Proposed conversion and extension to existing garage into ancillary accommodation, new driveway to front of property. This application affects the character & appearance of the Angmering Conservation Area.

Ariston Water Lane Angmering

Re: A/54/20/HH

HAPA ARCHITECTS			
Job Name			
Ariston, Water Lane, Angmering, Littlehampton			
Status	PLANNING	Drawing Type	PROPOSED SITE PLAN/ BLOCK AND PROPOSED GARAGE CONVERSION PLAN AND ELEVATIONS
Date	APRIL '20	Scale	1:50, 100 & 500 @ A1
Job Ref			WL_101
Drawing Number			L-200a

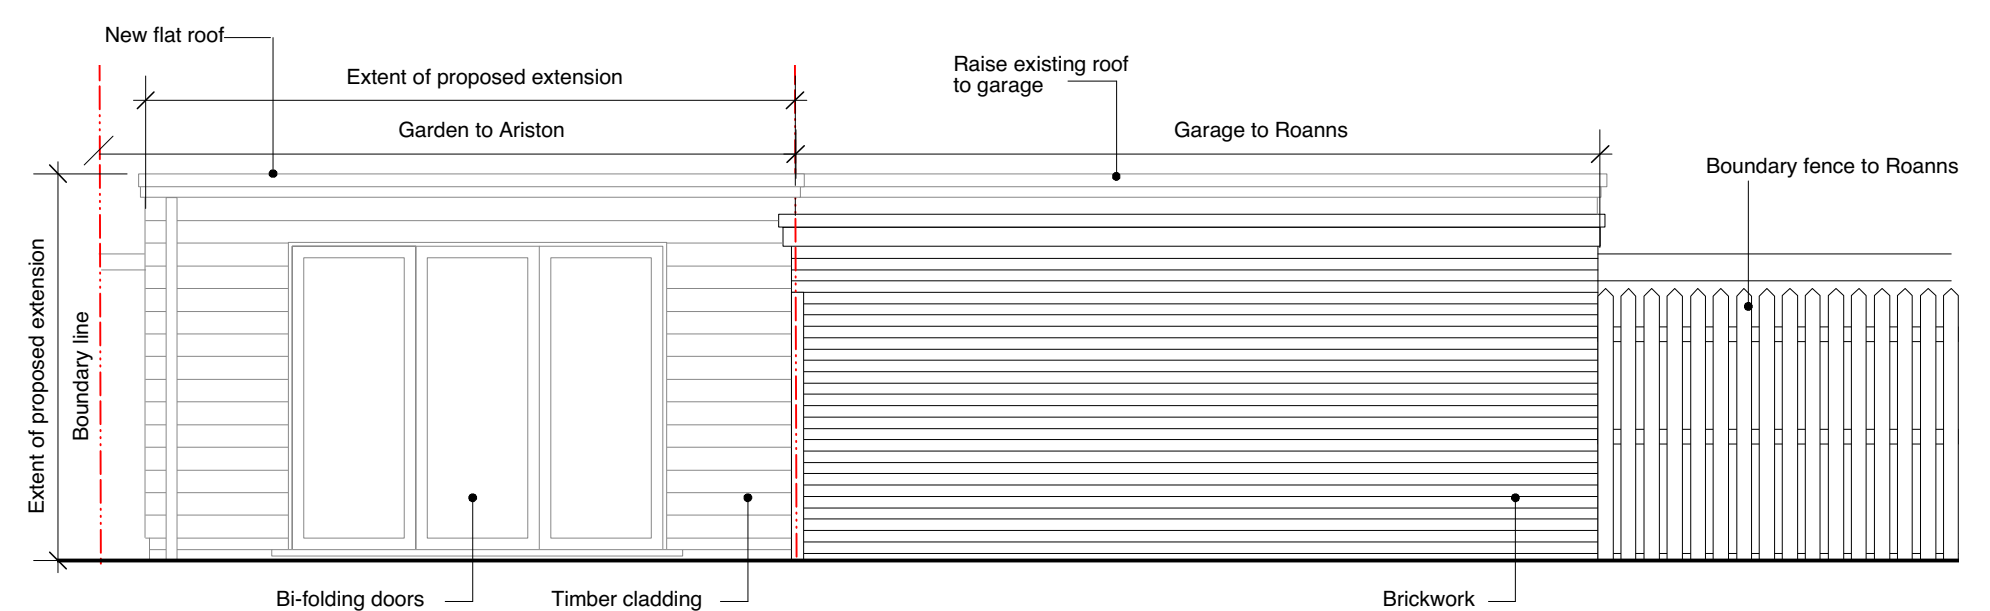
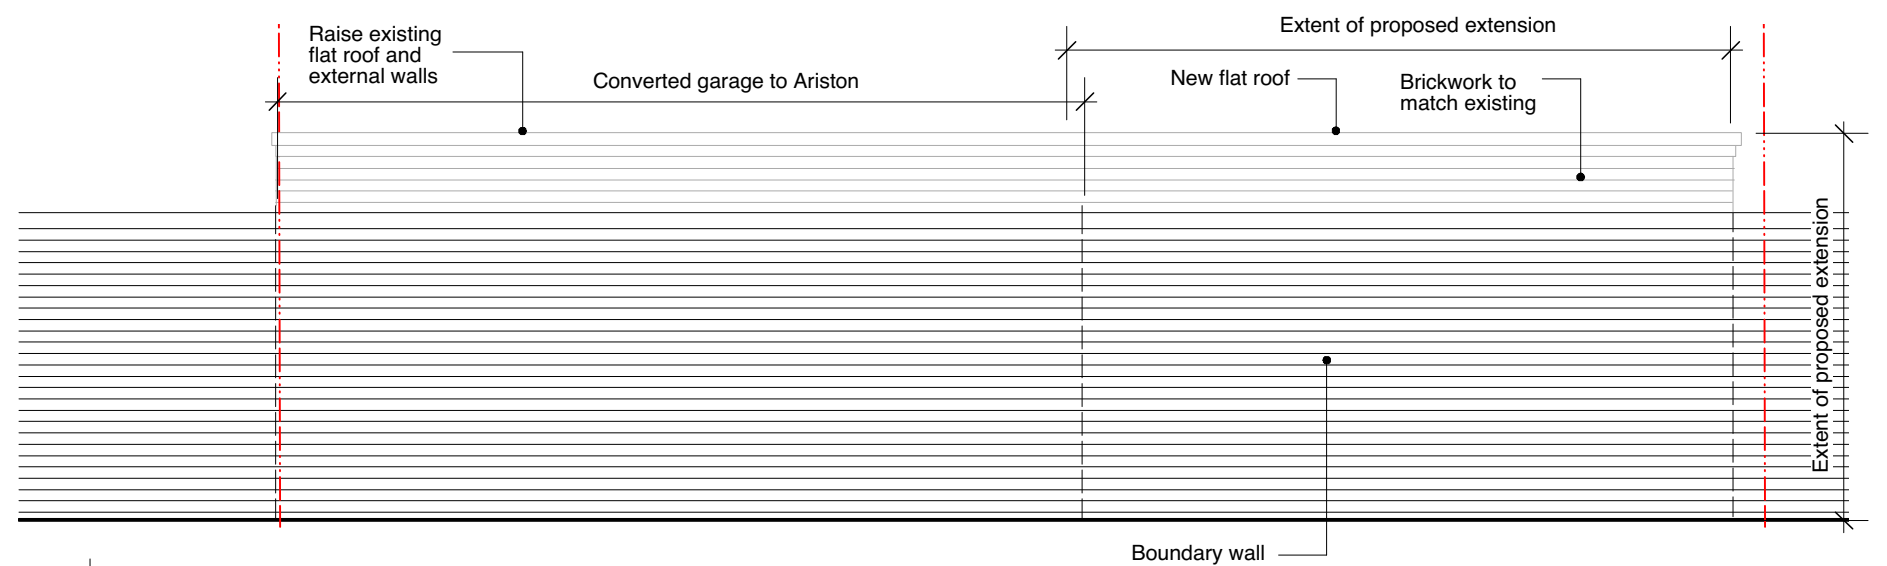
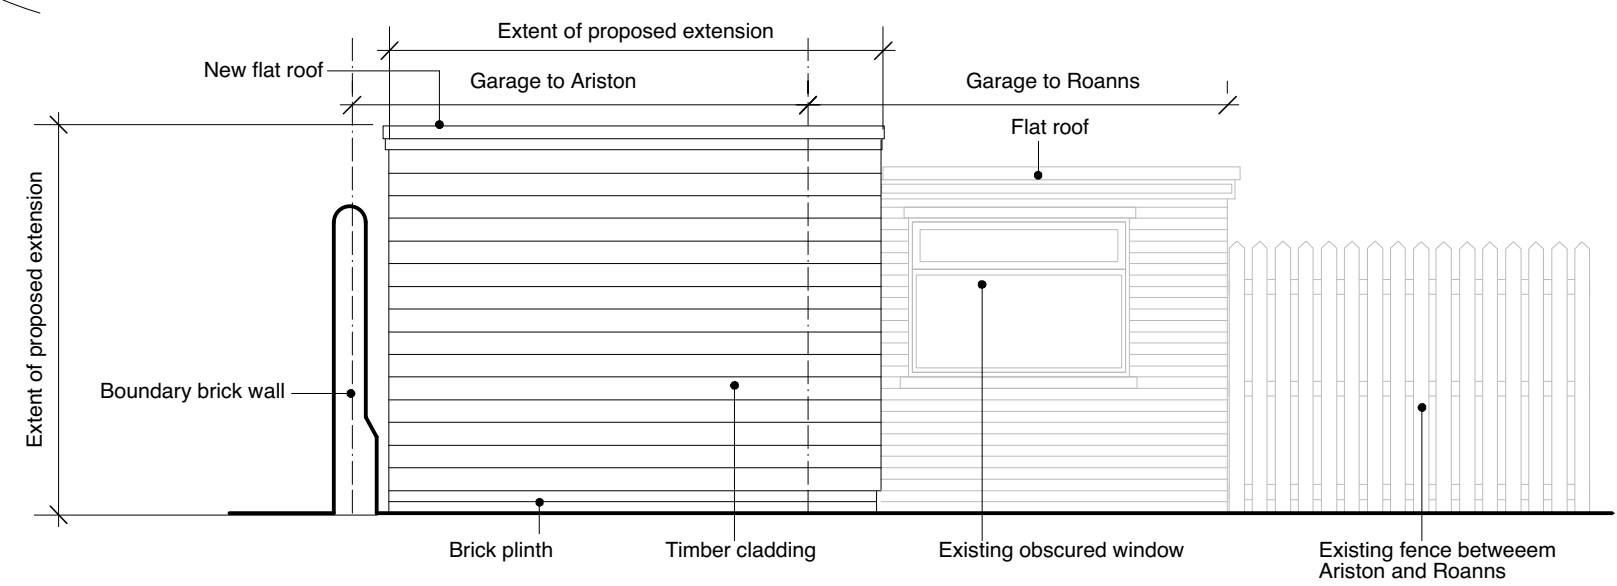
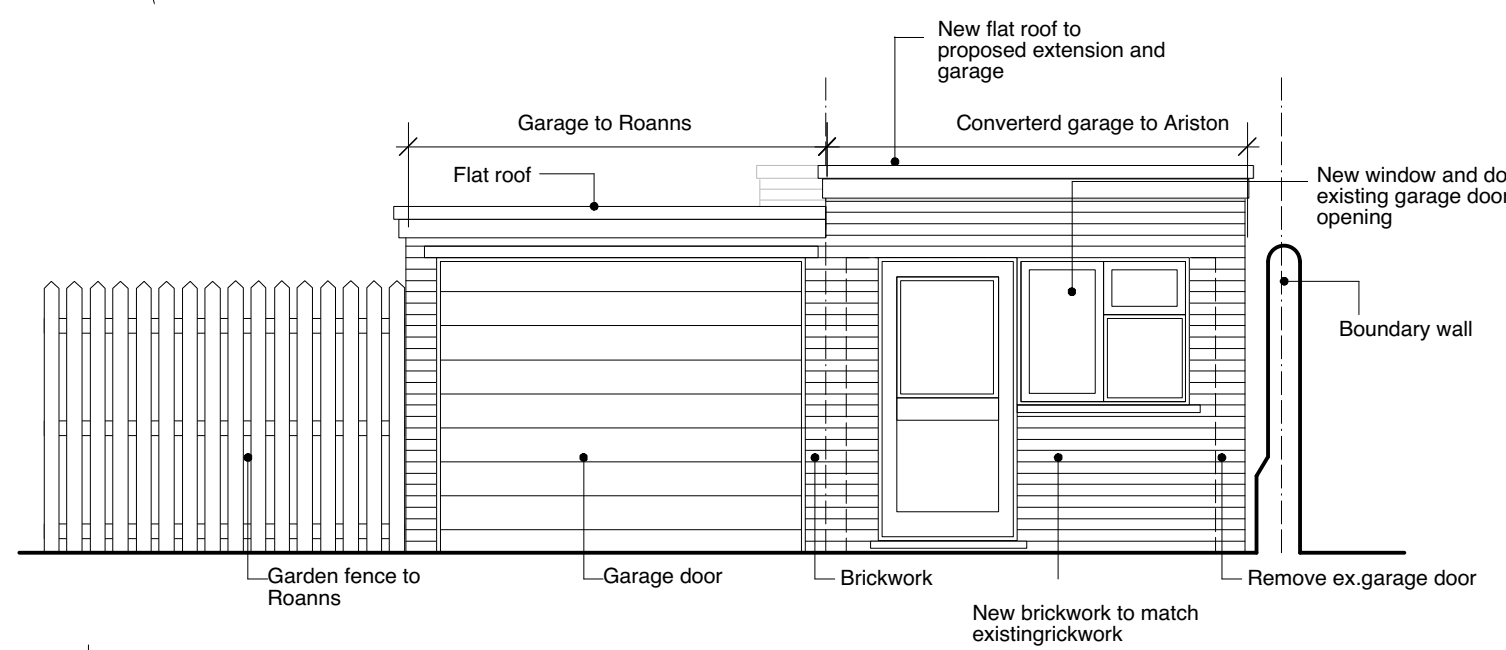
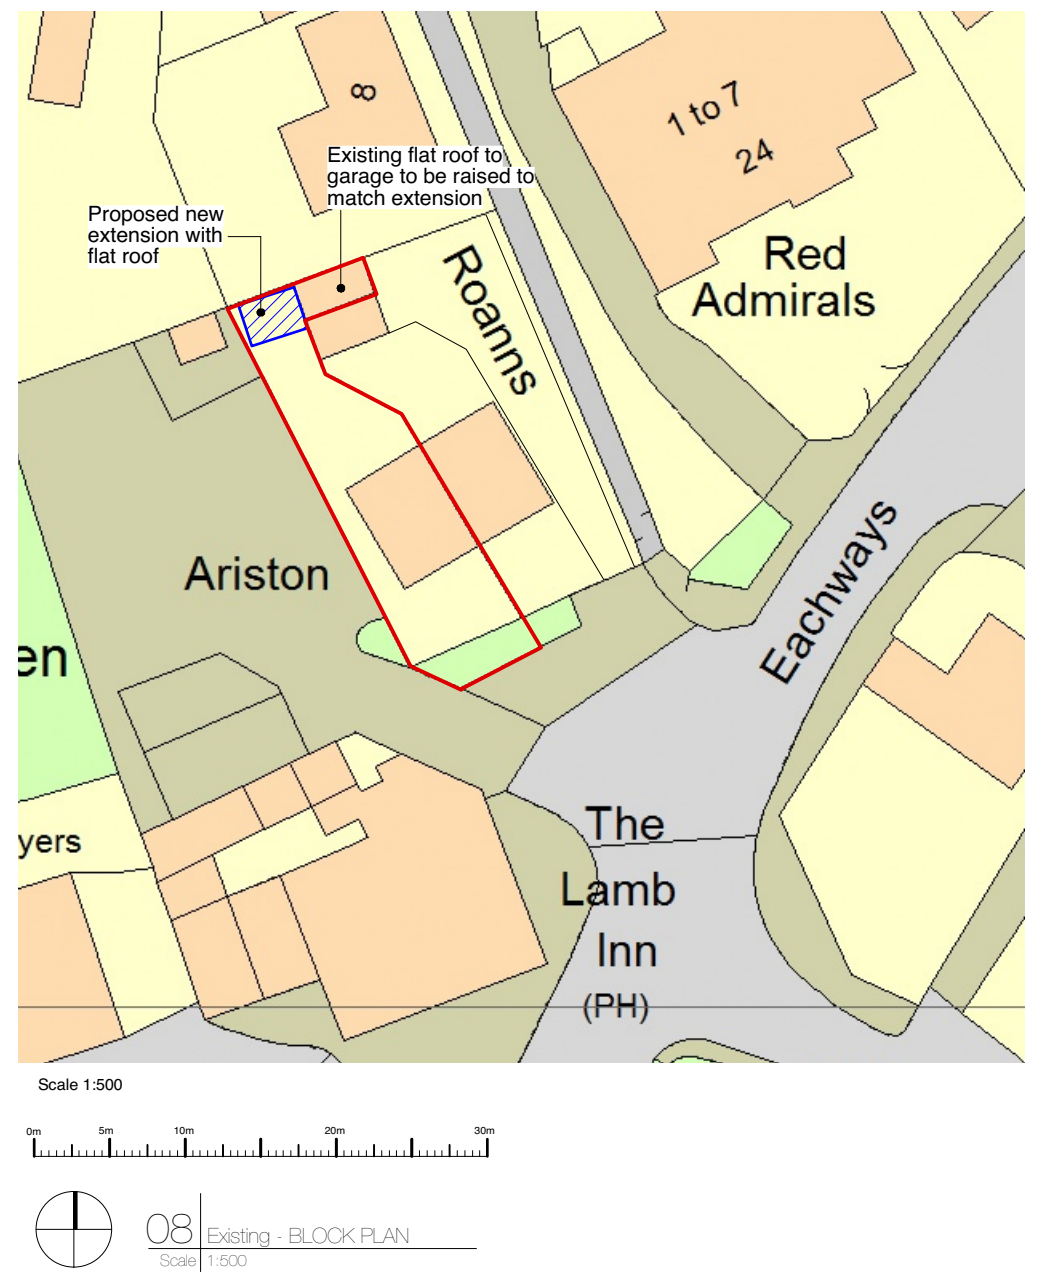
The plans submitted in respect of the application show a door and window on the east wall opening onto the land owned wholly by Roans; this would seem to suggest that the resident of the ancillary building (I have been advised by the applicant that the intended purpose of the ancillary building is to provide permanent accommodation for a relative) intends to use the land owned by Roans to access the newly created ancillary accommodation.

I object to a doorway on the east wall that will provide direct access onto land owned wholly by Roans being included into the construction.

2. Further to the above, the window on the east wall next to the door as described above will significantly reduce the privacy of the owner of Roans as this will look directly onto its private land.

I object to the window sited on the east wall of the proposed ancillary building.

3. The plans show that the existing flat roof shared by both garages will be replaced by an elevated section on the new construction; however, the plans do not appear to provide for any guttering that will drain surface water away from the elevated section to be captured within the boundaries of Ariston, instead implying that it will fall onto the flat roof of the garage owned by Roans.

Until revised and more detailed plans are submitted that demonstrate appropriate guttering is included I object to the change from a shared flat roof to one with an elevated section on the ancillary building.
